Kirklees Highways Development Management comments

2021/62/92086/W – Erection of 270 residential dwellings and associated infrastructure and access

Land at Bradley Villa Farm, Bradley Road, Bradley, Huddersfield, HD2 2JX

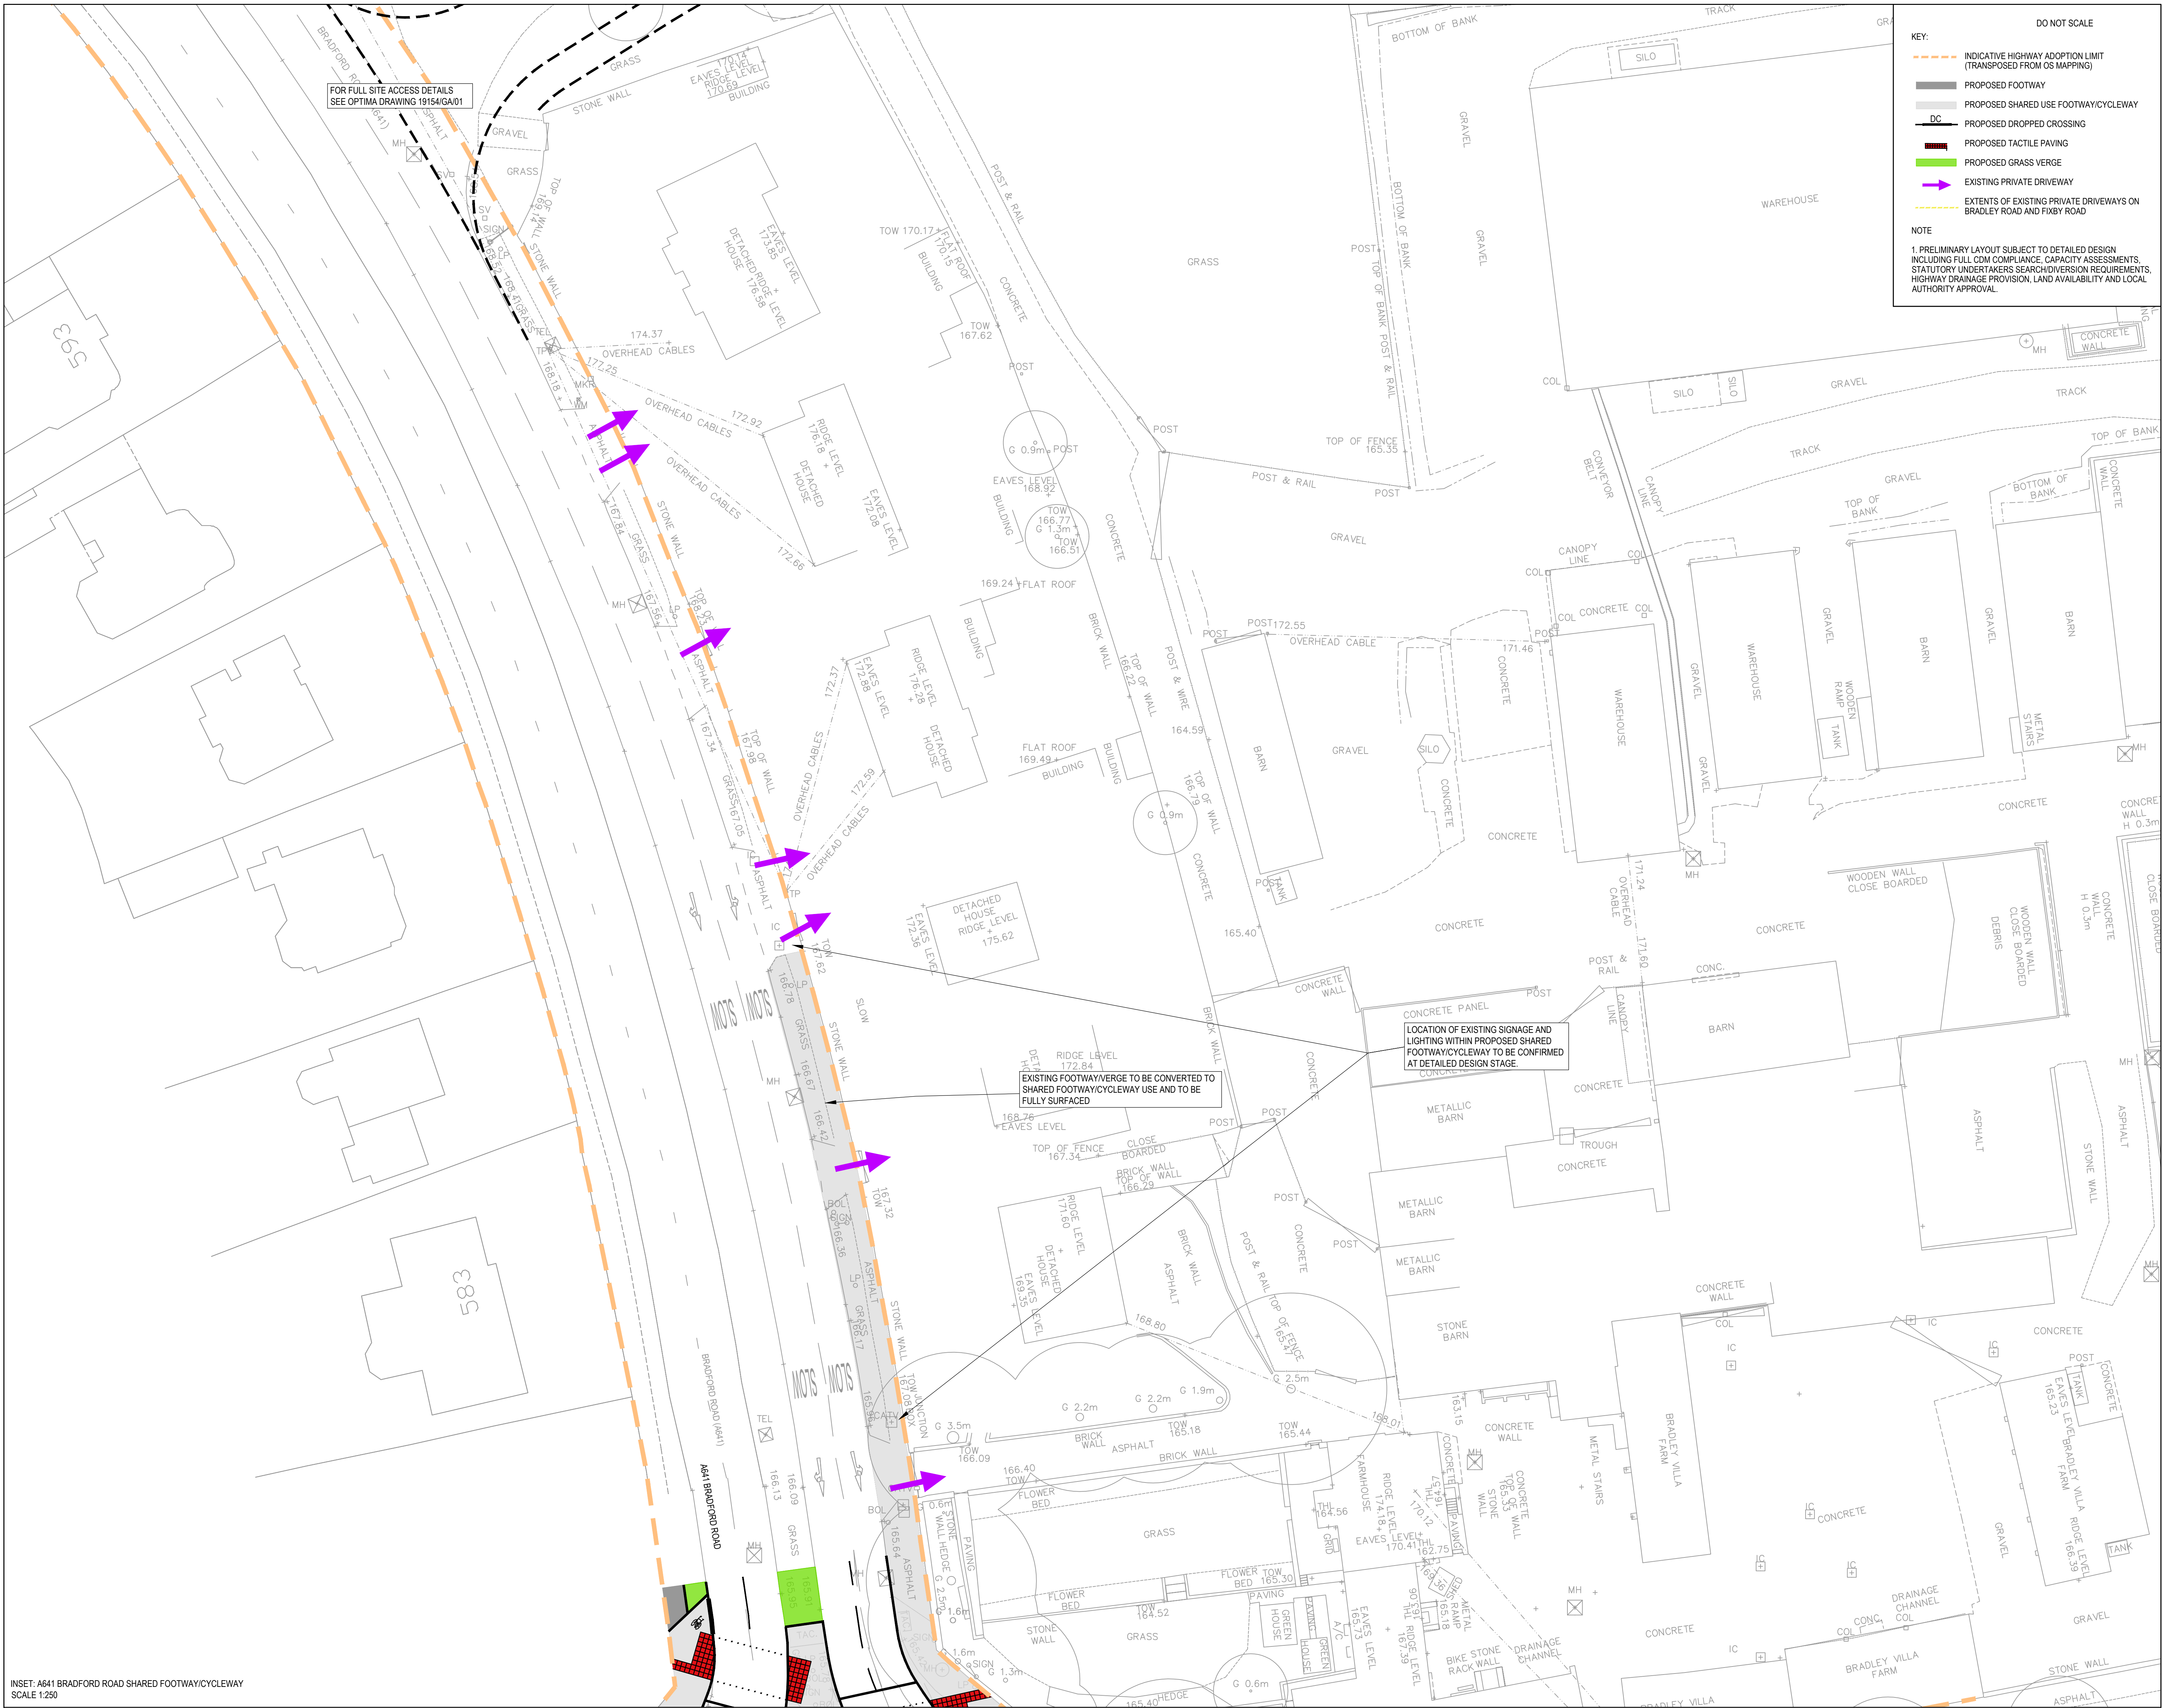
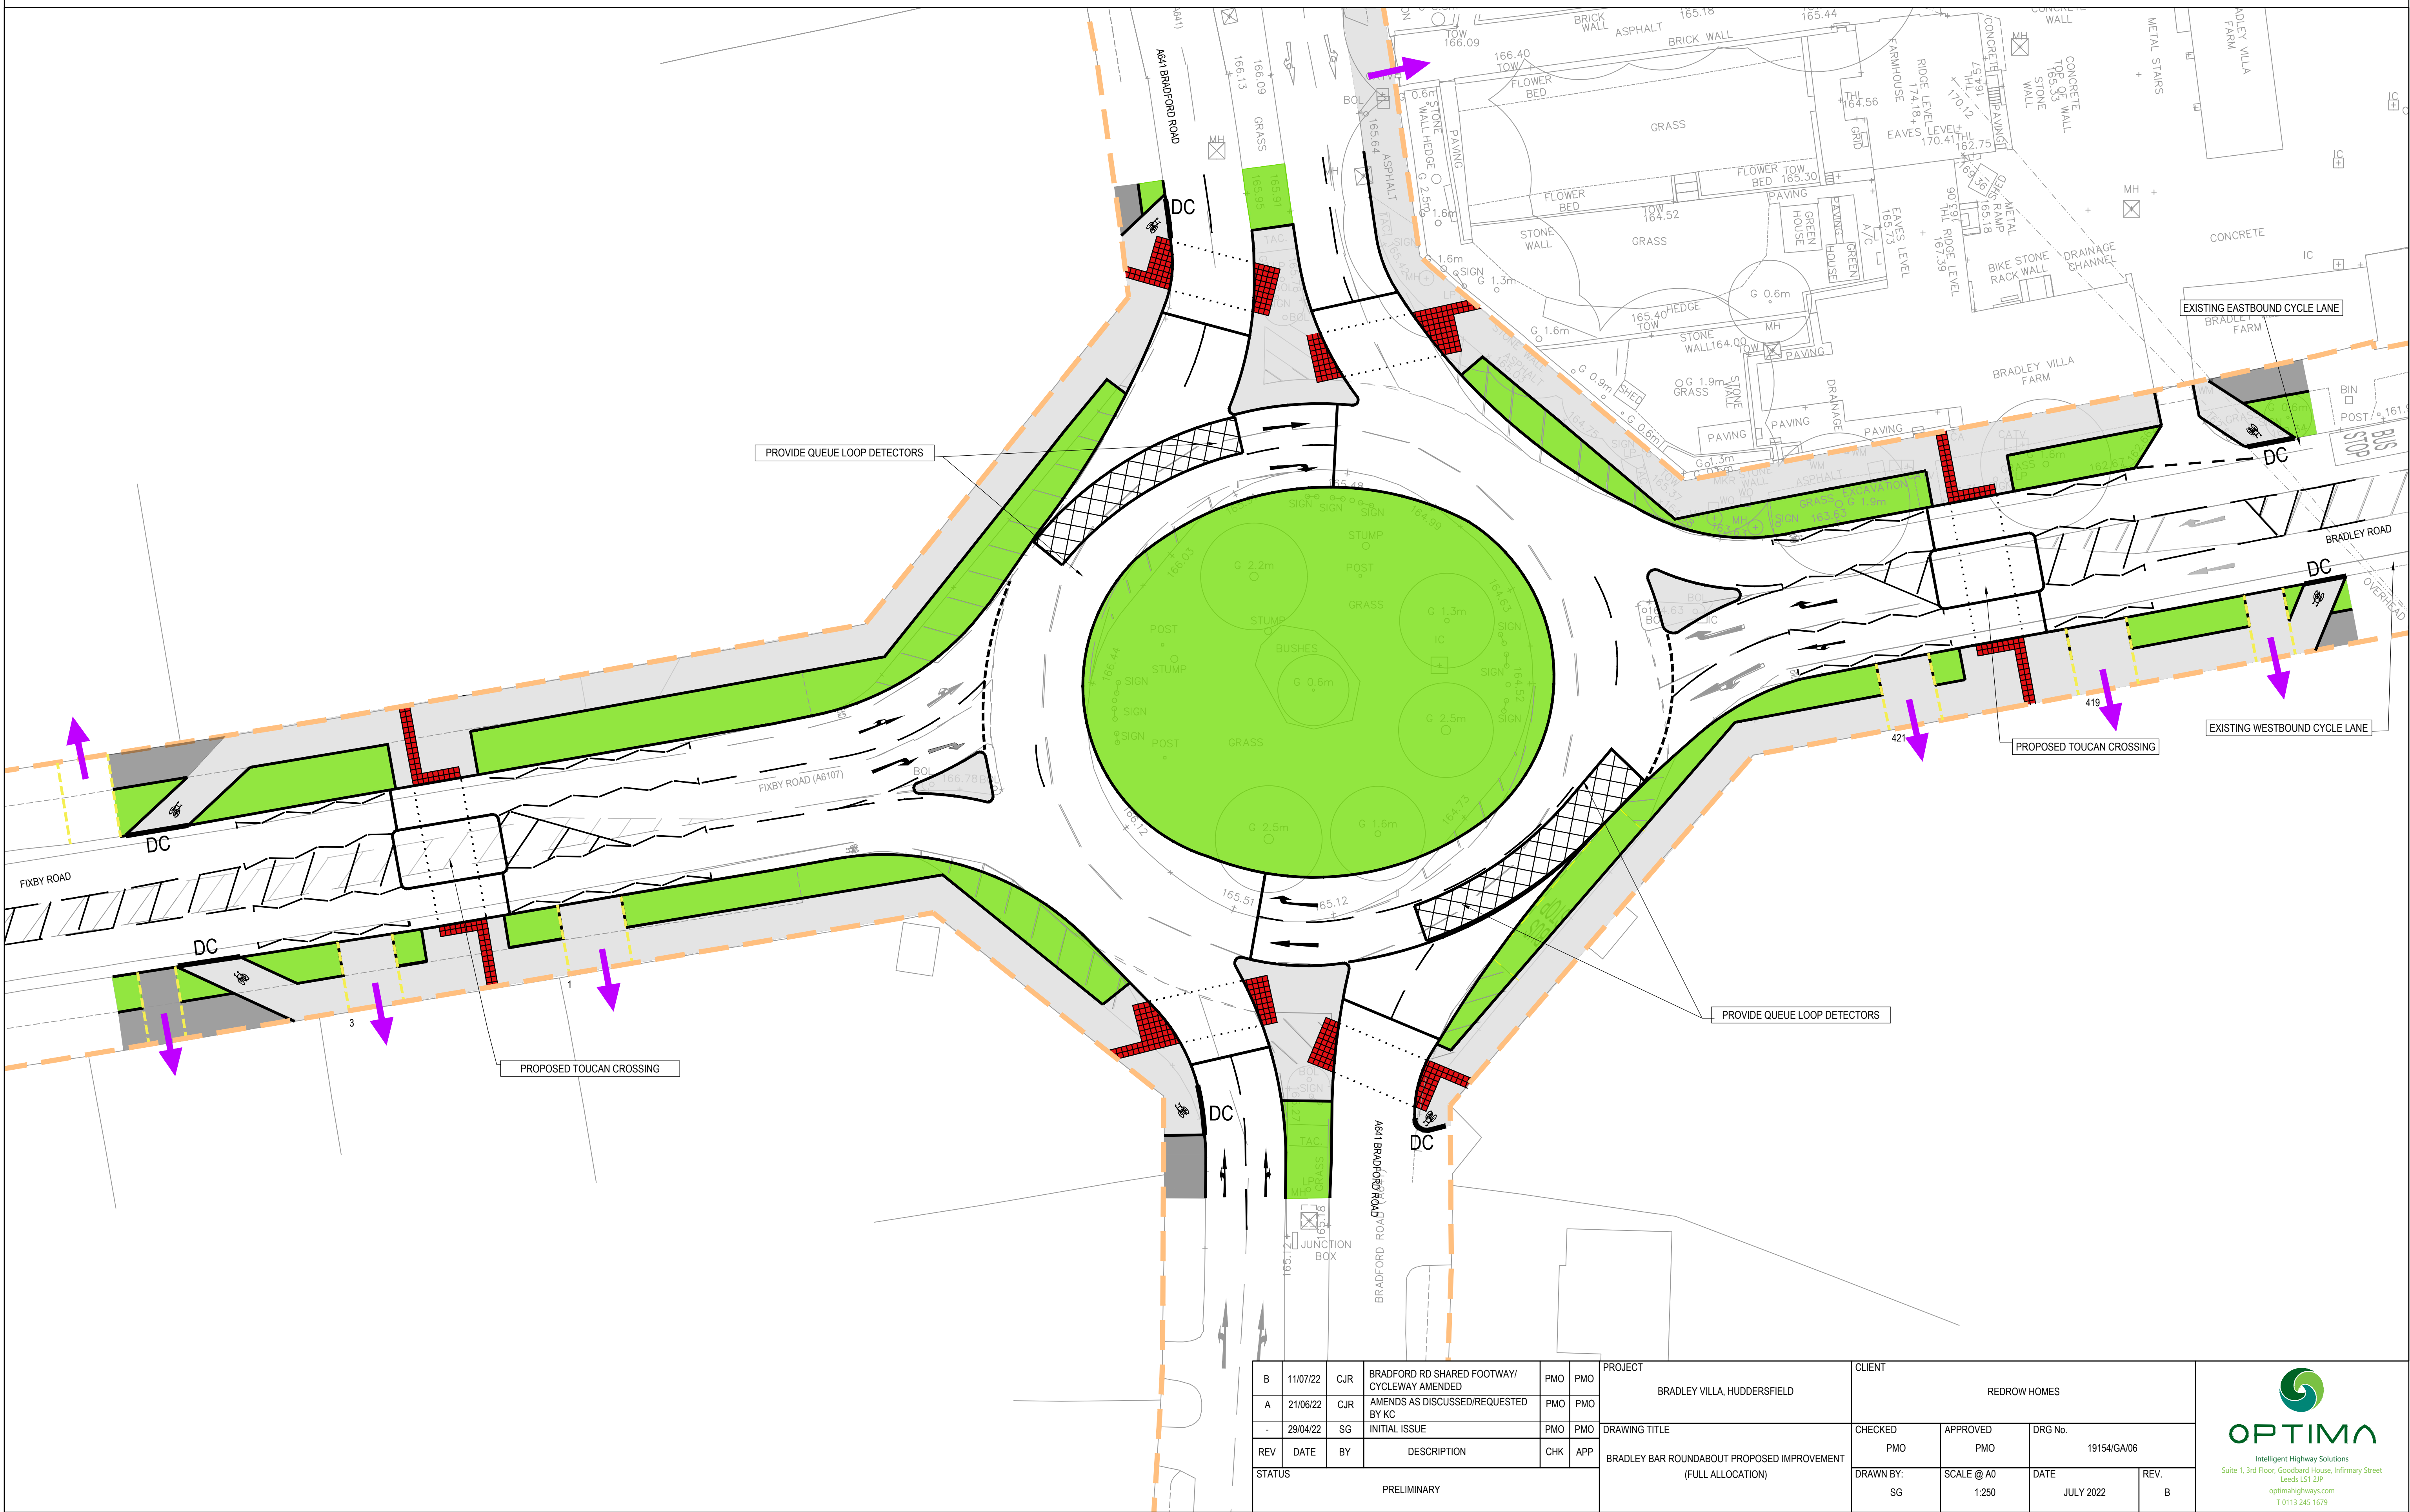
Kirklees HDM is concerned at the lack of existing (or proposed) formal pedestrian crossing facilities on the A641 Bradford Road. This is formed of a 40mph road with 2 north-bound lanes and 2 south-bound lanes.

Passengers alighting buses at the north-bound bus stop would have to cross 4 lanes of (40 mph) traffic. They may be weighed down with shopping bags, have small children to hold onto, using a pushchair or be disabled and reliant on a mobility scooter. There are serious concerns that vulnerable road users would be at serious risk when crossing the A641, particularly in low light or inclement weather conditions.

HDM has concluded that the provision of dropped kerbs and tactile paving (with a central refuge) does not form mitigation that sufficiently addresses these concerns. It is therefore requested that the application team explores the provision of a signal-controlled pedestrian

crossing at a suitable location that facilitates a pedestrian desire line between the site access and the north-bound, Bradford Road bus stop.
